Engineers Comments Regarding Surface Water Drainage

Application Reference:	Y/9/25/DOC	Reviewer Reference:	ADC/PC
Planning Officer:	Amber Willard	Date of Review:	30/06/2025
Site Name:	Fleurie Nursery Lake Lane Barnham PO22 0AL		
Application Description:	Approval of details reserved by condition imposed under reference Y/26/24/PL relating to condition number 4 - surface water drainage scheme, condition number 5 - discharge flows to watercourses, condition number 6 - maintenance and management of the surface water drainage system and condition number 10 - Biodiversity Enhancement Layout.		
Assessment Number:	1 of 2

Application Reference: Y/9/25/DOC Site Name: Fleurie Nursery Lake Lane Barnham PO22 0AL	Initial Issue Date: 21/02/2025 Issue Date: 30/06/2025 Reviewer Reference: ADC/SB & PC
--	---

Sel Controflow 600-900Ø Orifice Chamber

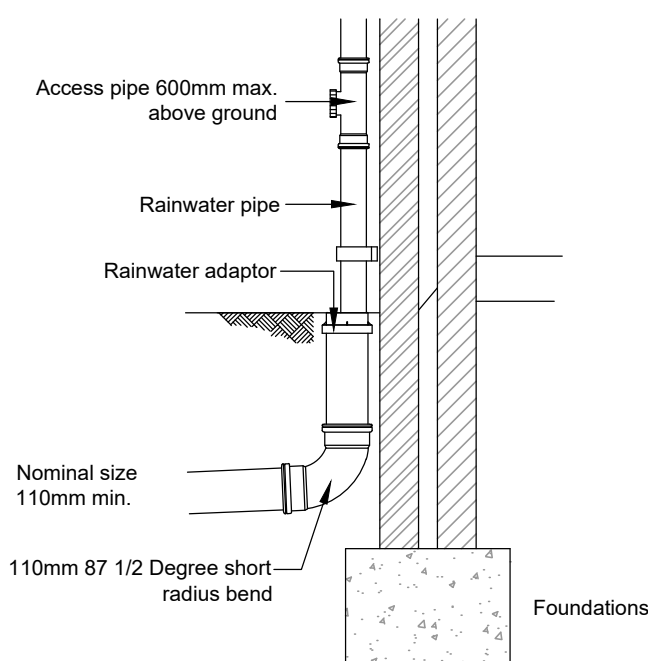
11.	The orifice for S5 is described on the layout as being 500mm diameter. This is assumed to be a typo (confused with the chamber diameter), please correct.	Orifice chamber diameter has been updated to 600mm diameter and orifice diameter to 20mm.	Orifice chamber is shown as 900mm diameter. 20mm orifice noted. Comment closed.

14.	Please detail the overflow level of the Sel Controflow 500 Orifice Chamber.	Overflow level is now indicated on orifice chamber detail.	It is noted that the overflow level of 9.150 is higher than manhole S3 cover level (9.00) upstream, so in the event of a blockage at the orifice, excess water may overflow from S3 before the formal overflow at S5 operates. Please advise.
